Application No: LU/141/25/PL

Site Address: 57 River Road Littlehampton BN17 5DD

Description of works: Partial demolition of number 57 River Road, change of use & re-development to provide a flatted development comprising 9 No. apartments with private amenity space, parking & cycle storage, including the partial demolition of the adjacent boundary wall to provide a new pedestrian access & the creation of a floating pontoon with resident morning spaces (resubmission following LU/251/21/PL). This application affects the character & appearance of the Littlehampton River Road Conservation Area & is in CIL Zone 4 (Zero Rated) as flats.

Thank you for your internet representation made on 28th August 2025 which has been recorded as an objection with the comments as follows:

PROJECT 55-57 RIVER ROAD, LITTLEHAMPTON		TITLE PROPOSED FACADE RETENTION INTENT	
DATE 25/10/2024	SCALE 1:100 @ A3	STATUS CODE -	STATUS FOR INFORMATION
DRAWN MG	CHECKED MG	PROJECT No. 3421	DRAWING No. 3421-HSK-200 (SHEET 01/01)
			REV P1

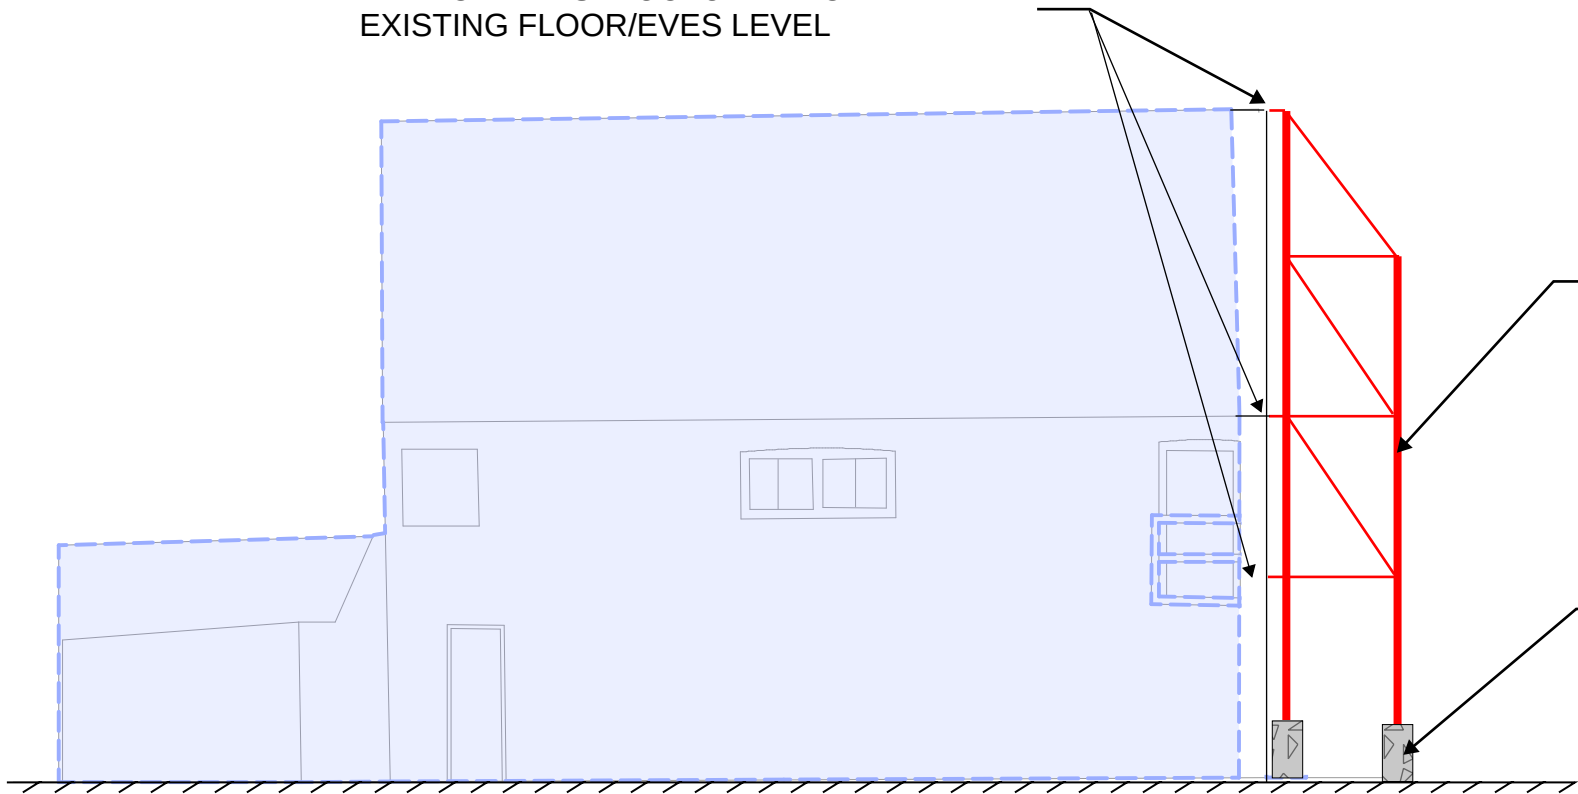
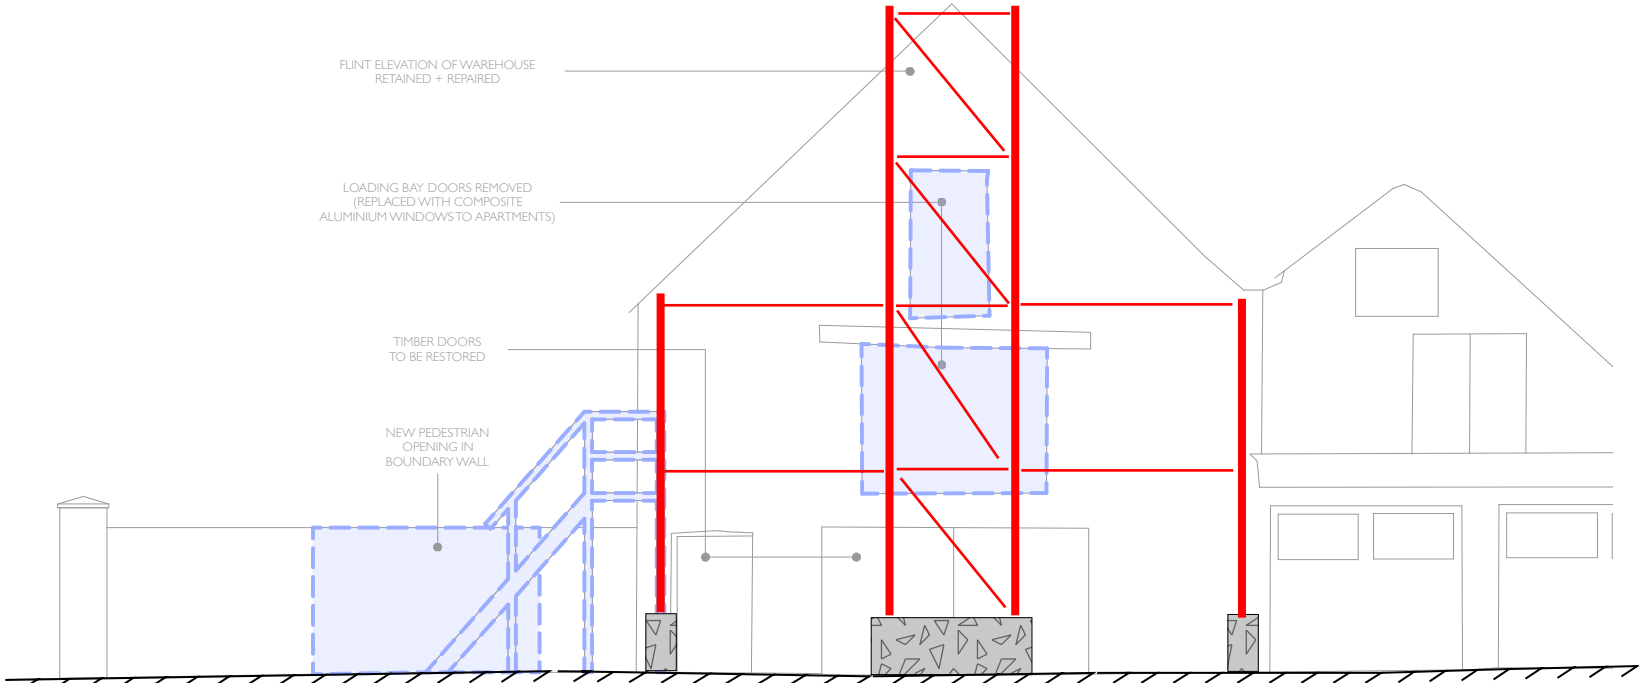
1) This is a characterful historic building in a conservation area. It is a local Landmark. and the last of its kind. it is therefore very disappointing that the whole south-east elevation will be demolished (as confirmed by drawing no. D_051). While facing the yard, nevertheless this elevation is highly visible from the highway and contributes greatly to the historic street scene. The proposal could and should have incorporated retention of at least part of this wall.
